Department of Planning and Environment

Subject: **Winterbourne Wind Farm (SSD-10471) – Environmental Impact Statement (EIS)**

Detailed advice to DPE Planning & Assessment regarding the Winterbourne Wind Farm (SSD-10471) - EIS

Table 4-5 Strahler Stream Order (>3rd order) within the Project Area

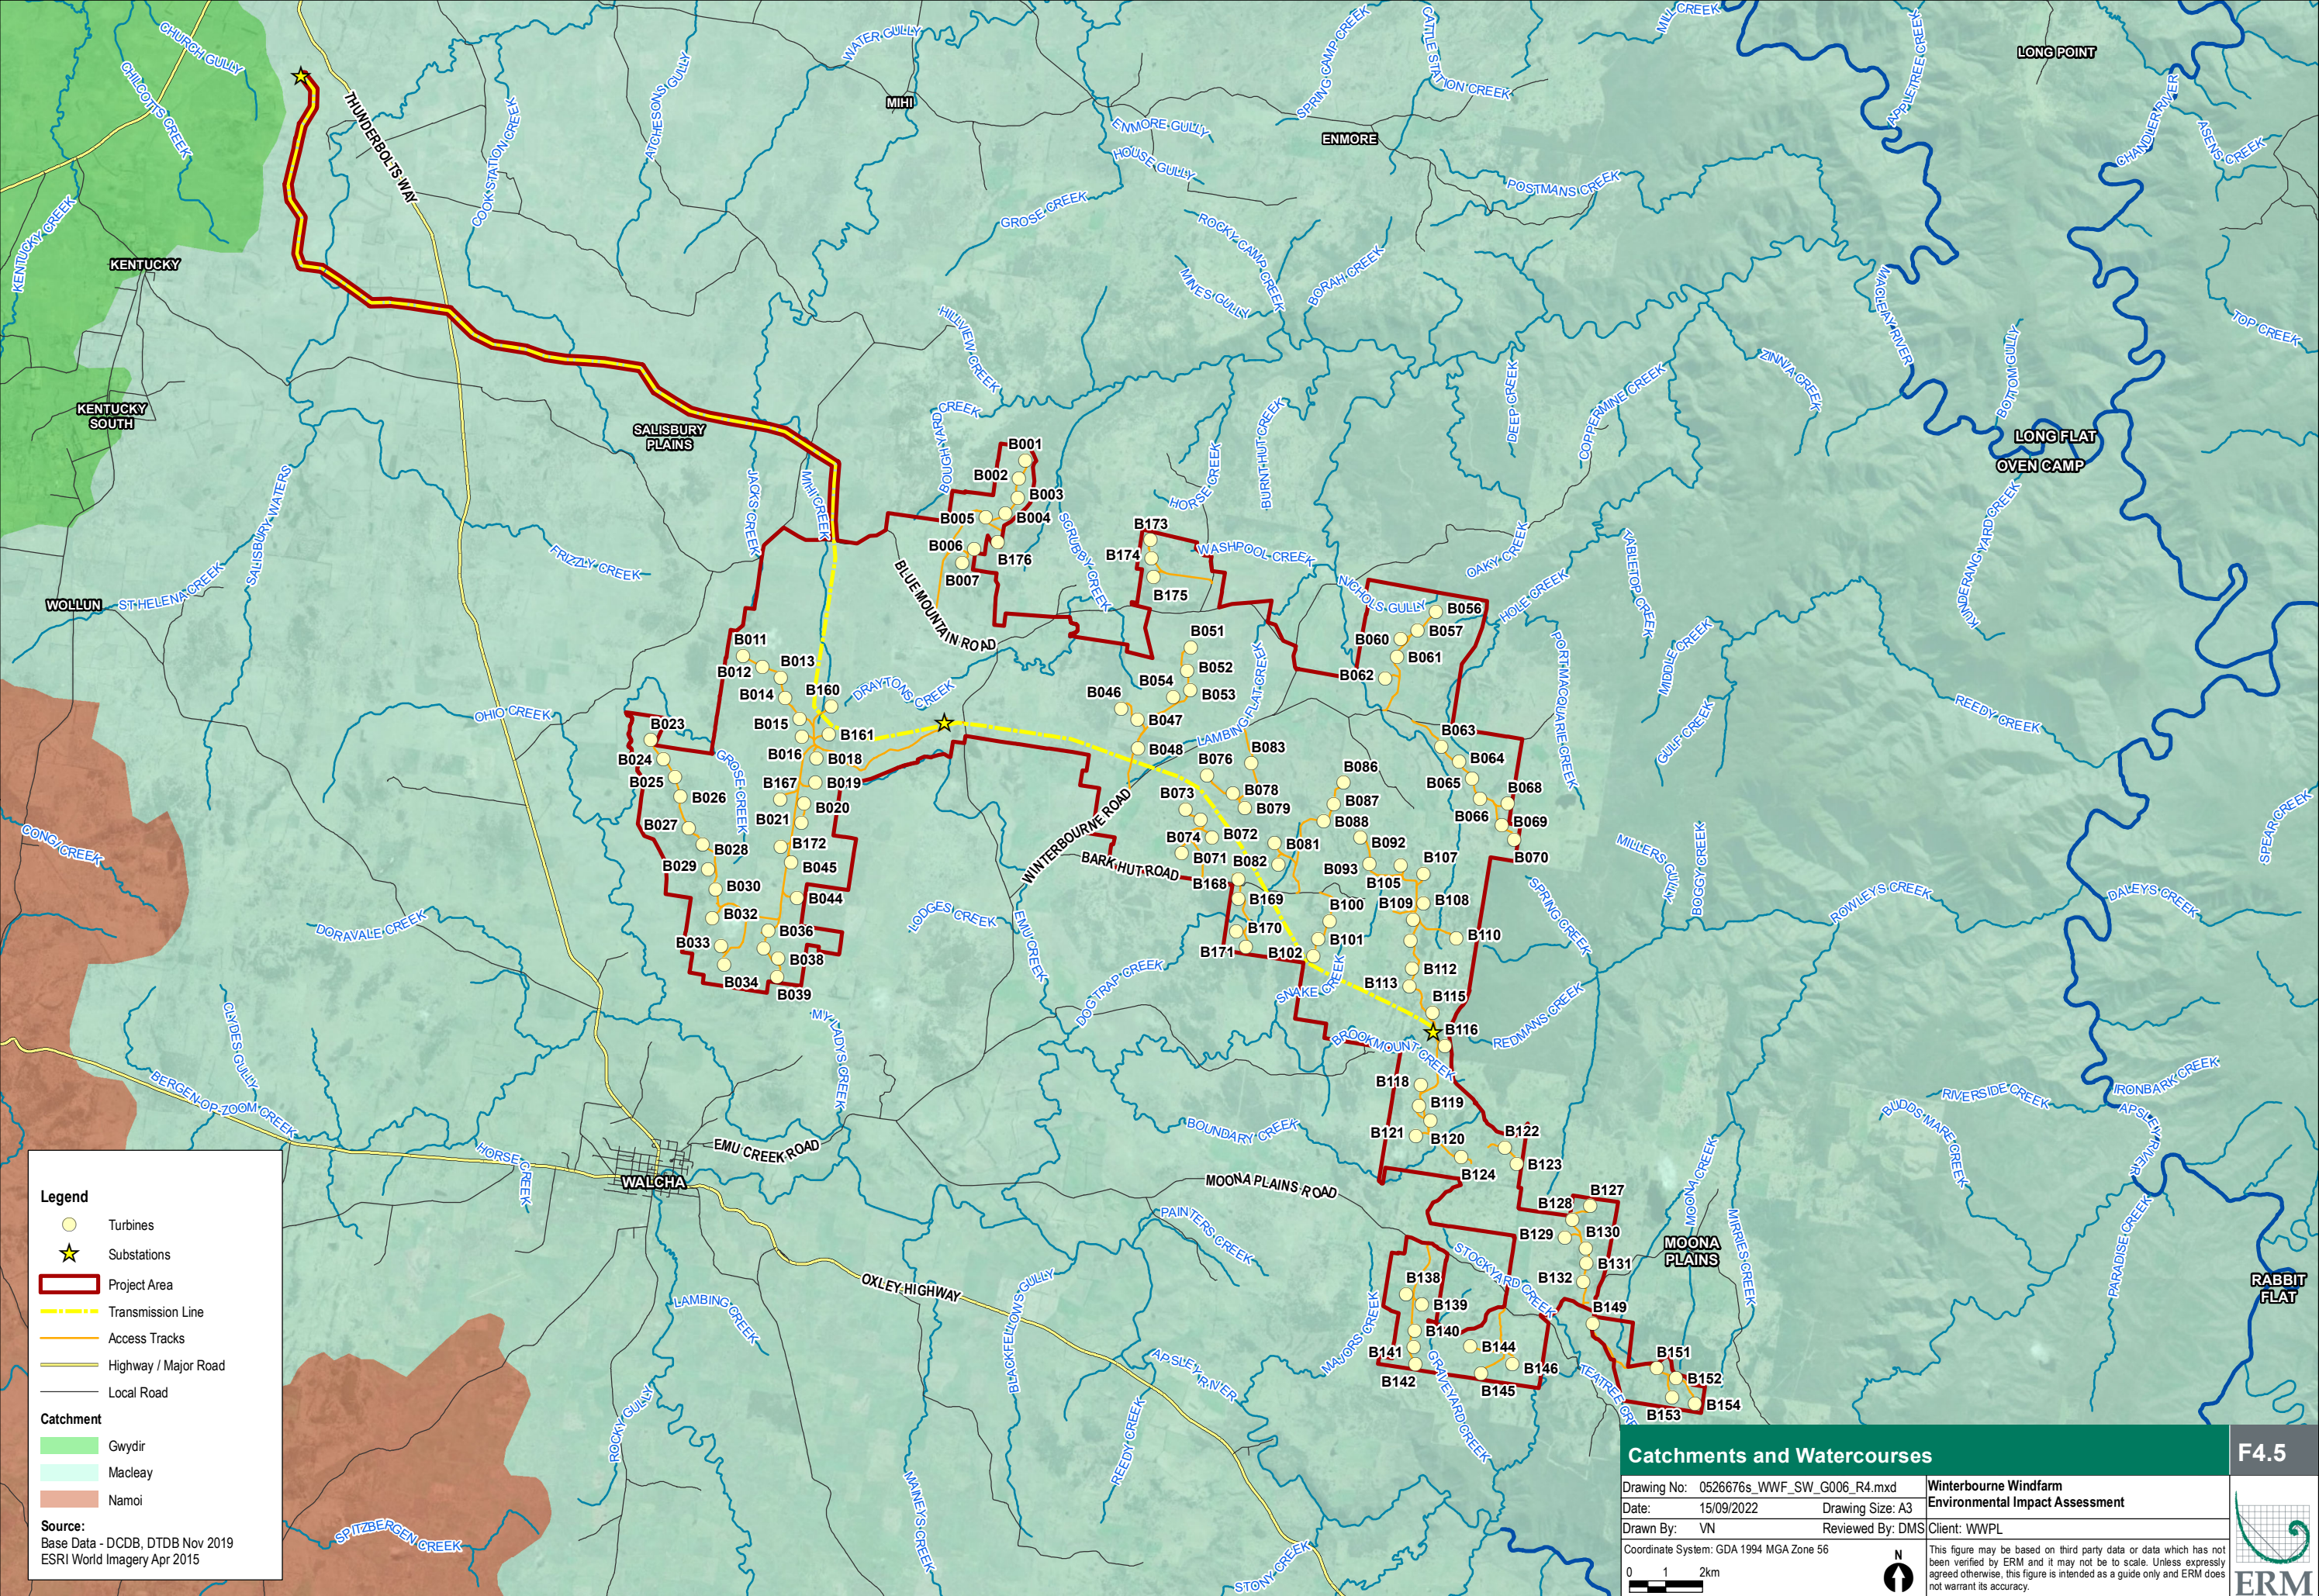
The proponent notes that 3rd order and above watercourses within the site do not meet the definition of waterfront land under the *Water Management Act 2000* (Section 6.8.3.3 of the EIS). This does not appear to be correct as many of these do show banks, flows and/or vegetation changes. All works within waterfront land should show due consideration to the Guidelines for Controlled Activities on Waterfront Land including setbacks, outlets and crossings. It is noted that if works are assessed as a part of the State Significant Development application, then a controlled activity approval would not be required.

The proponent should demonstrate the project has shown due consideration to the Guidelines for Controlled Activities on Waterfront Land.

The proponent should ensure works within waterfront land are in accordance with the Guidelines for Controlled Activities on Waterfront Land.
